Address: 43 Meadow Lane Huddersfield HD7 5EX

Application number: 2021/90128	
What is the application for?:	Erection of single storey extension and roof terrace to rear
Address of the site or building:	41, Meadow Lane, Slaithwaite, Huddersfield, HD7 5EX
Postcode:	HD7 5EX

Side Elevation

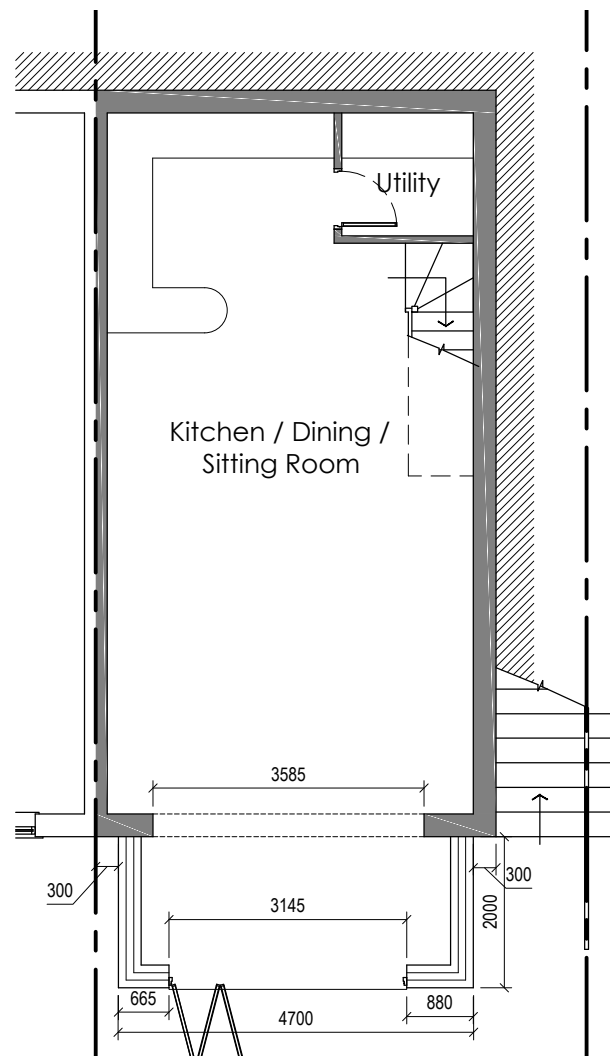
Type of comment: An objection	
Do you wish your comments to be published on the website anonymously?	No
I feel a solid brick wall of nearly 4 metres high will impact on the amount of light reaching my lounge and patio. If the 2nd storey in other words the walls to the balcony were to be made of glass this would be preferable.
